From:
Sent: 09 March 2026 15:33
To: DC Admin
Subject: Planning Application 2025/90033 - Erection of 11 dwellings adj 916 Halifax Road
Attachments: Planning 090326-1.pdf; Damaged wall & temporary fence.jpg; nonmaintained1.jpg; nonmaintained2.jpg; nonmaintained3.jpg; Plot 2 boundary.jpg

The development is unacceptable to 902 Halifax Road in its present form. Please consider the following:-

DRAWING TITLE
Proposed Plots 3 and 4

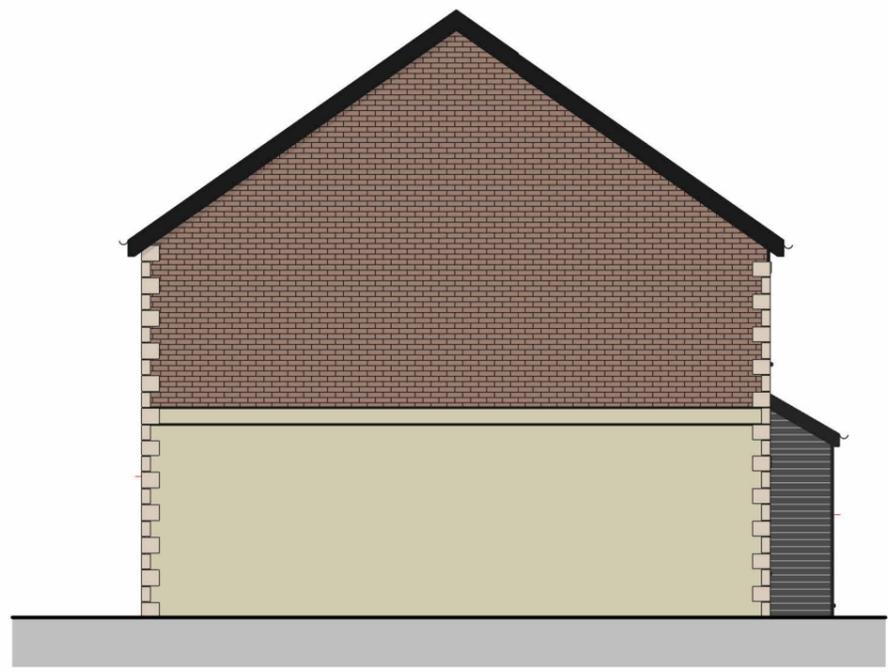
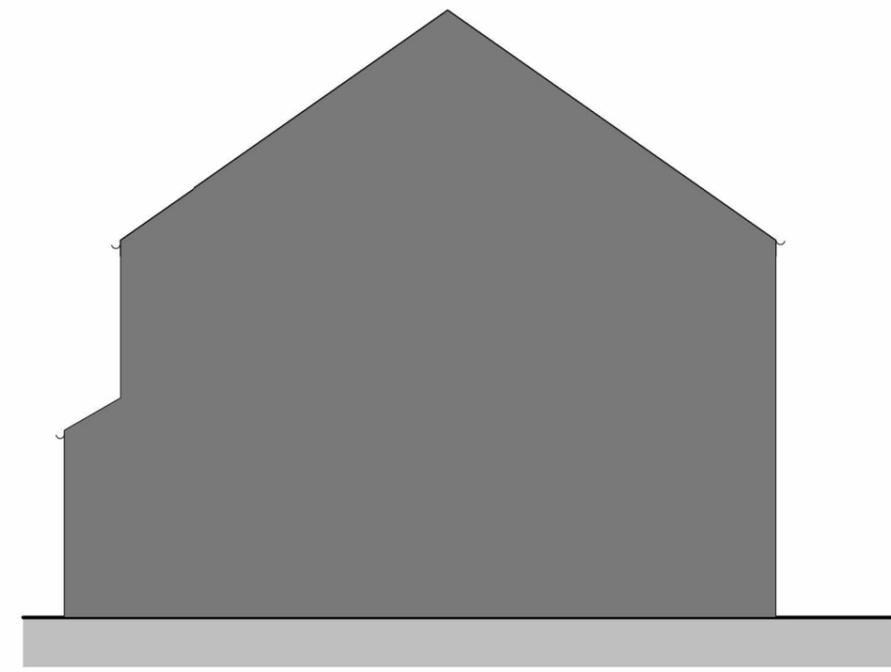
look out onto a wall and roofline. Our rear garden view from the house and balcony will overbear on the houses of plots 3 & 4 restricting their private amenity space.

Proximity of Plot 2 is a concern given the side of 902 is around 7m above ground level. Potential that digging the foundation may cause subsidence.
